PLANNING AMENDMENT

H16/0975/96

PLOTS 1-46, HOLLAND PARK, OFF BOURNE ROAD, SPALDING, LINGS.

DETAILS OF LANDSCAPING, PILL BOX AND
OPEN SPACE BOUNDARIES.

DATE OCT 1996 DRAWING No. 96009 / 009

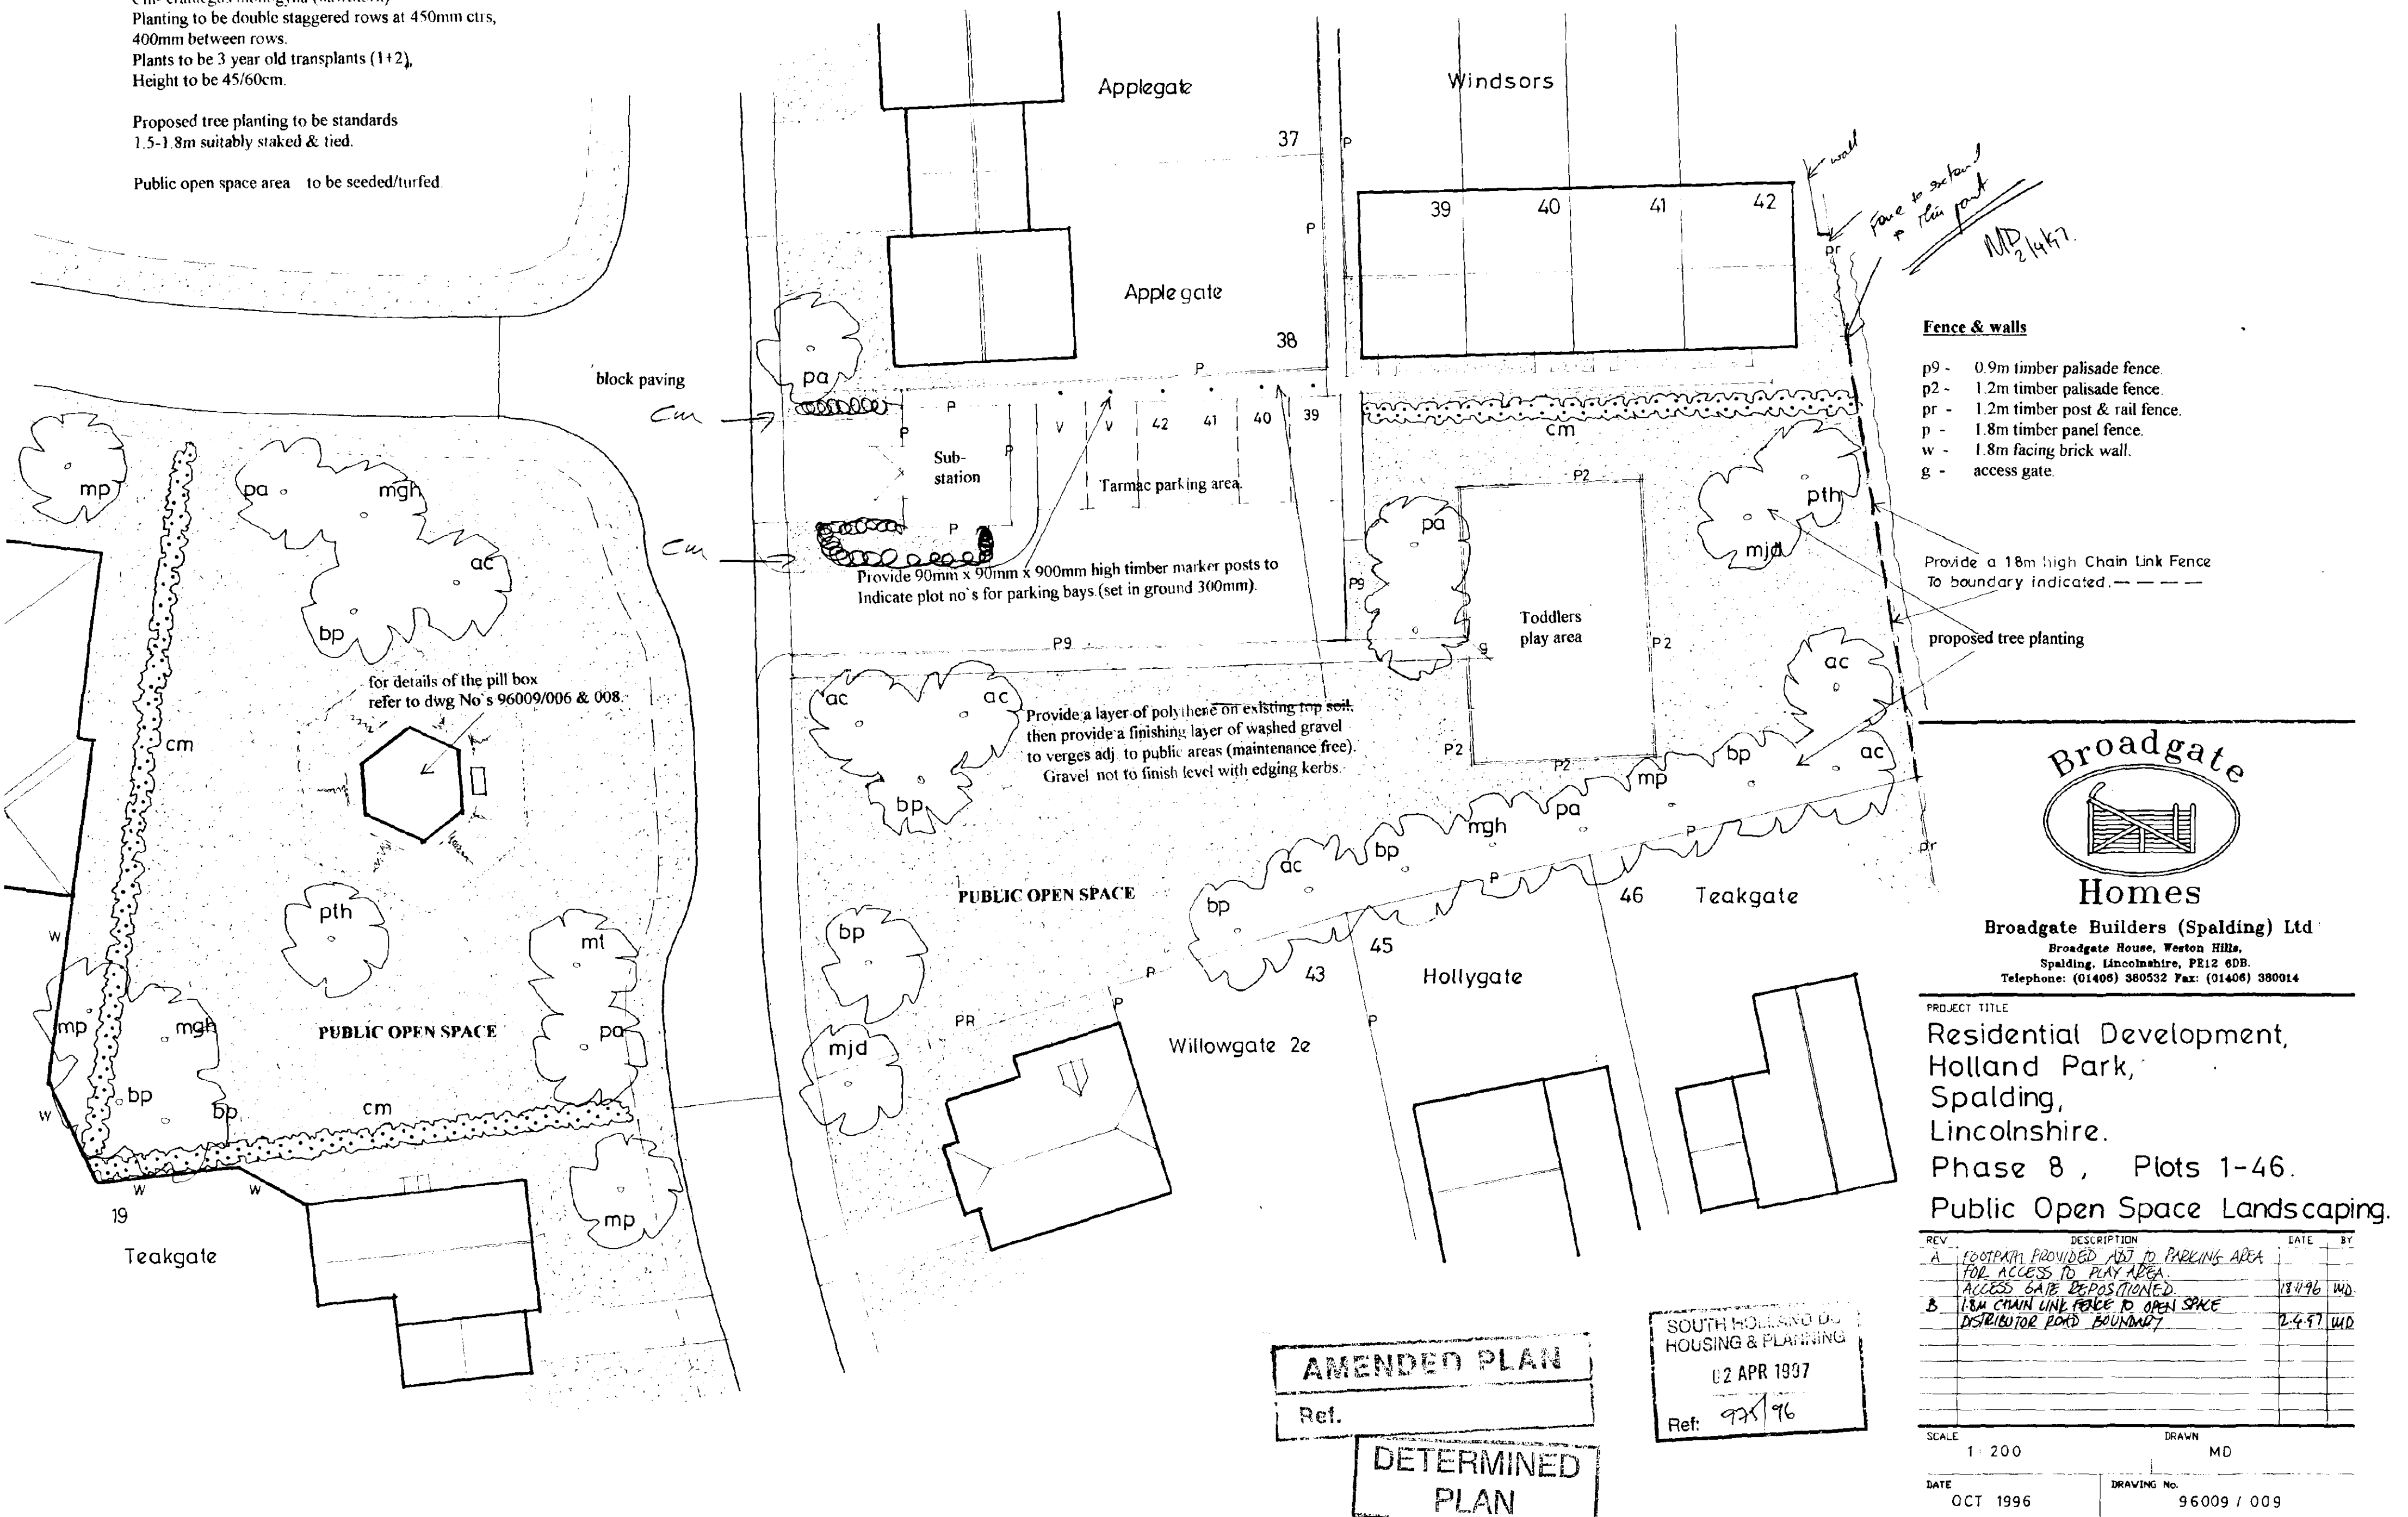
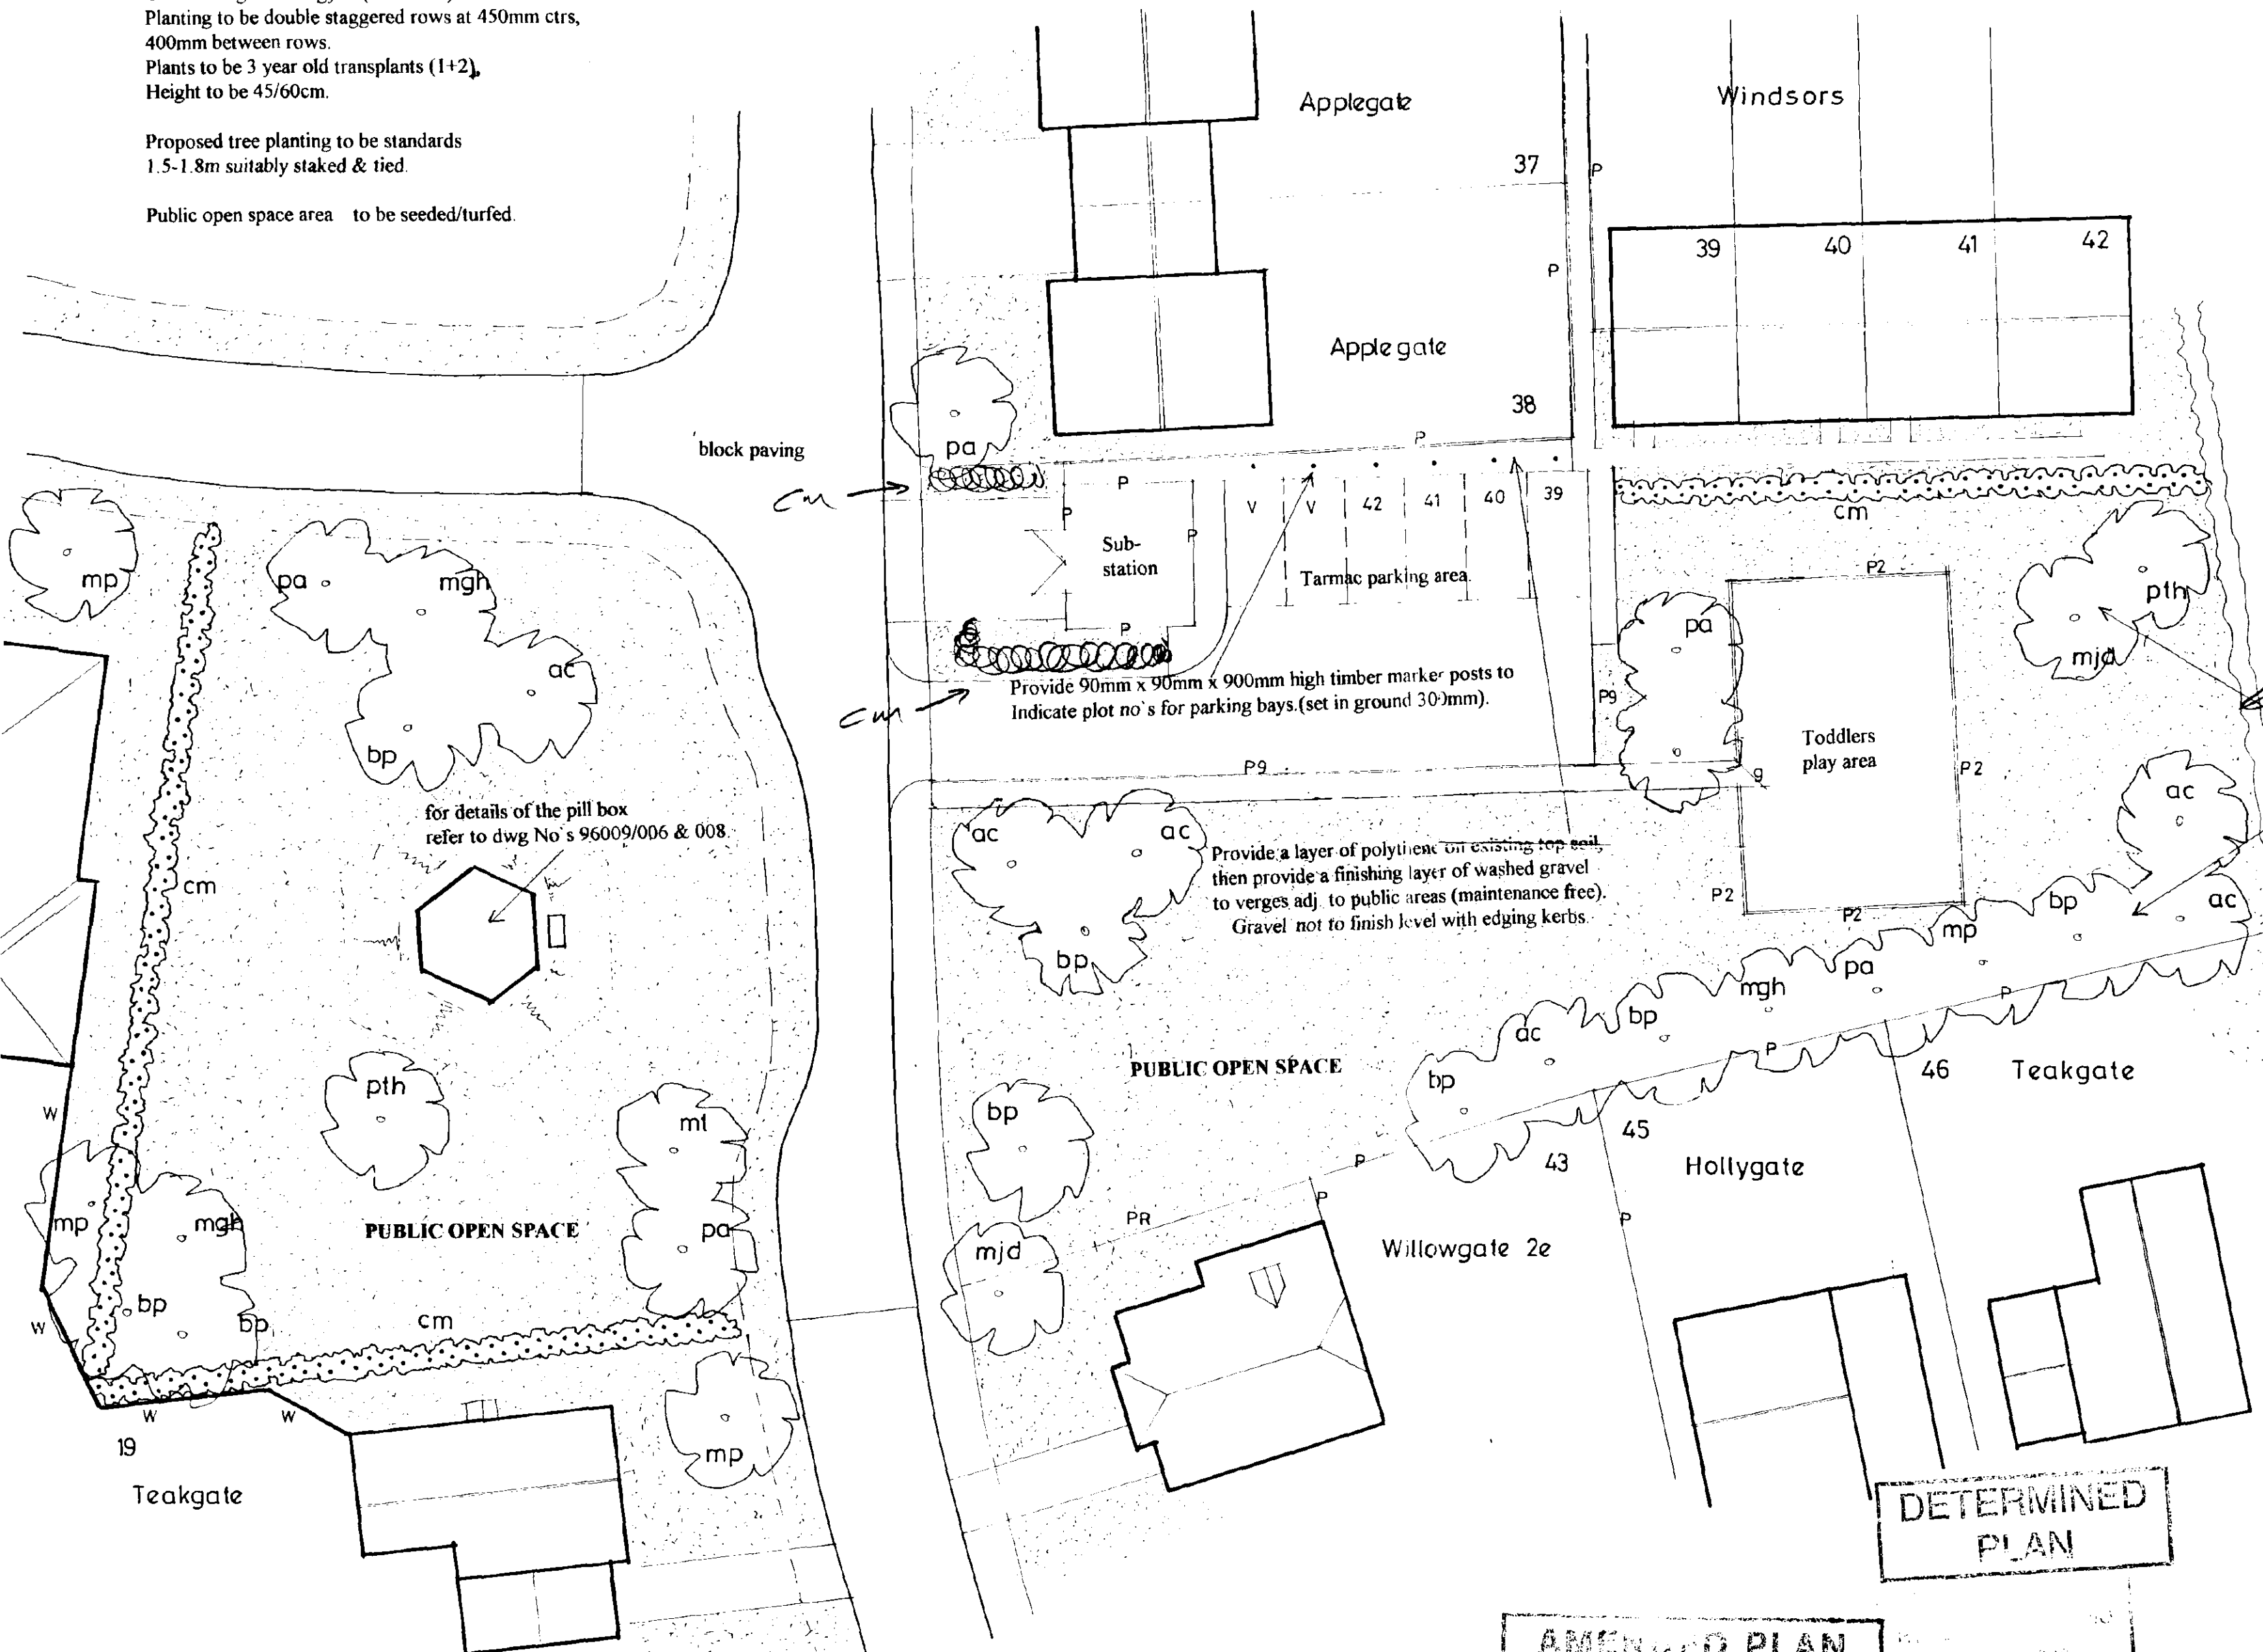
FOOTPATH PROVIDED ADS TO PARKING AREA
ACCESS GATE RE-POSITIONED TO
TODDLERS PLAY AREA.
